Rezoning Transportation Analysis

Petition Number: 2021-125

Revision Log:

Date	Description
09-17-2021	First Review (WLB)
11-22-2021	Second Review (AO)
01-25-2022	Third Review (AO)
02-21-2022	Fourth Review (AO)

**RZ-1.0**

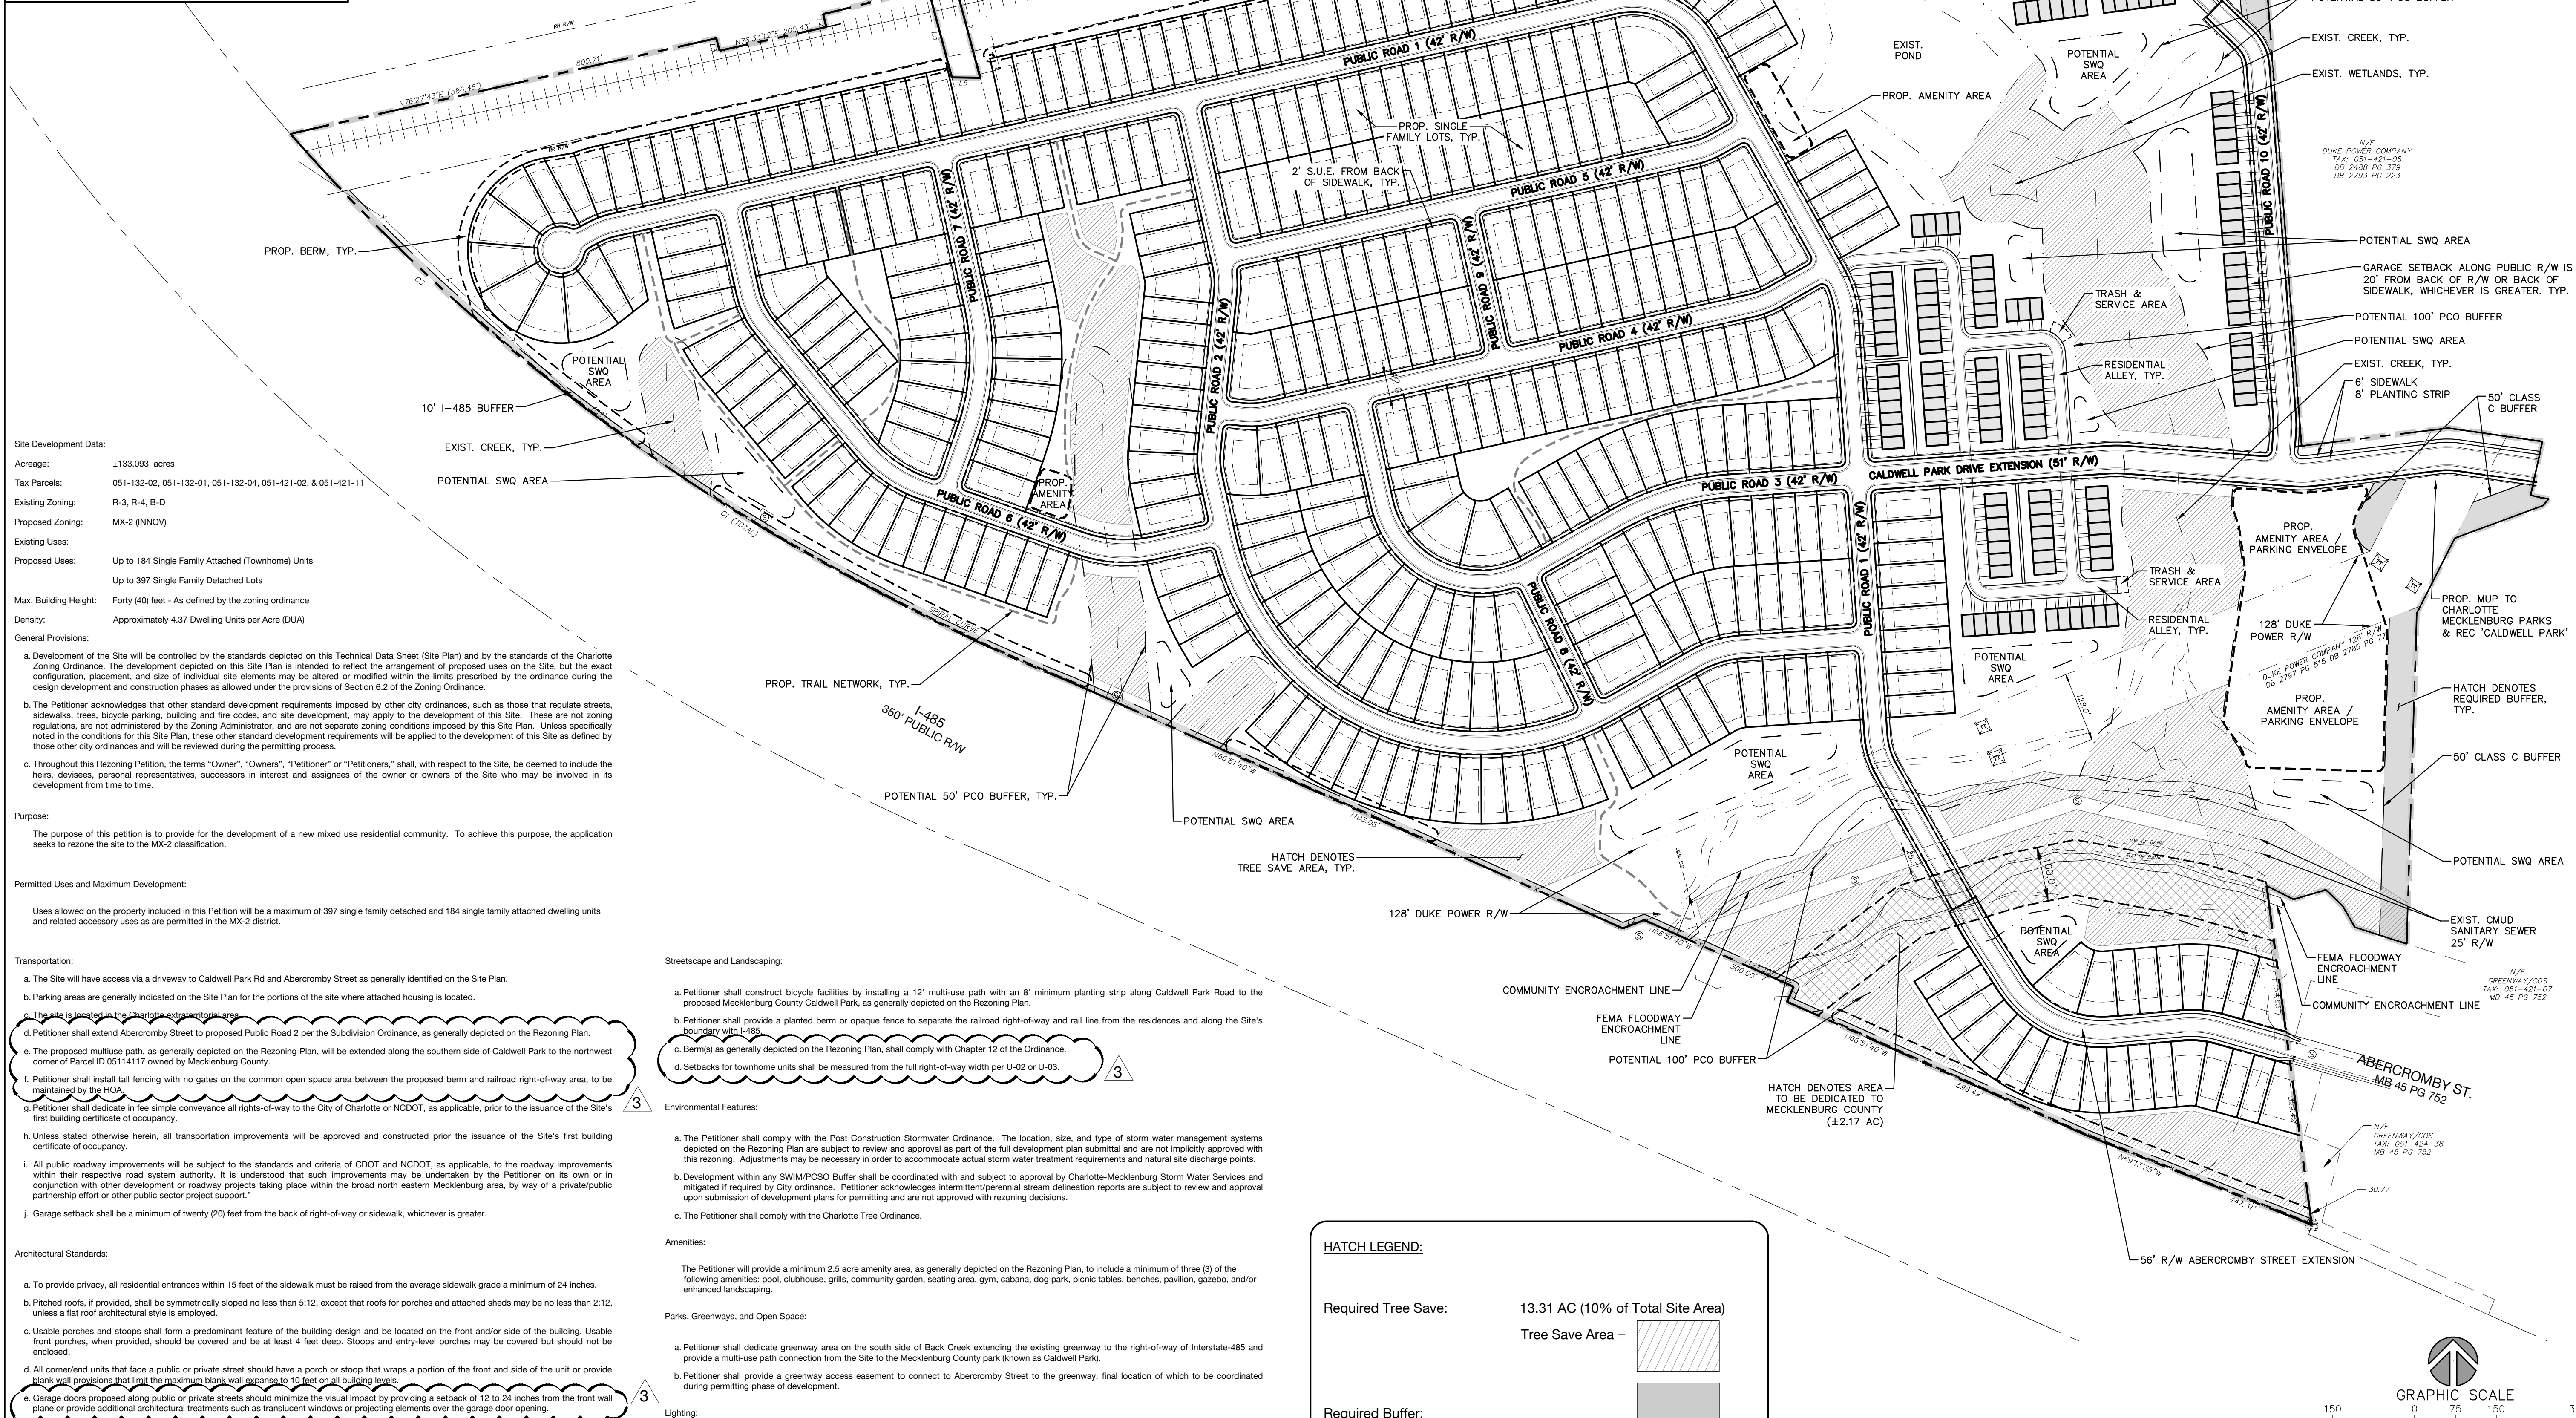
10. **Outstanding Comment from 1-25-22:** Add conditional note(s) committing to extend Caldwell Park Drive to proposed Public Road 1 as depicted on site plan per the Subdivision Ordinance.

12. **Outstanding Comment from 1-25-22:** Site plan and conditional note(s) revisions are needed to commit to the construction of noise walls between the I-485 right-of-way and the home lots that back to I-485. The wall should be placed within open space to allow for the HOA to maintain it. Site plan and note say planted berm or opaque fence instead noise wall along I-485.
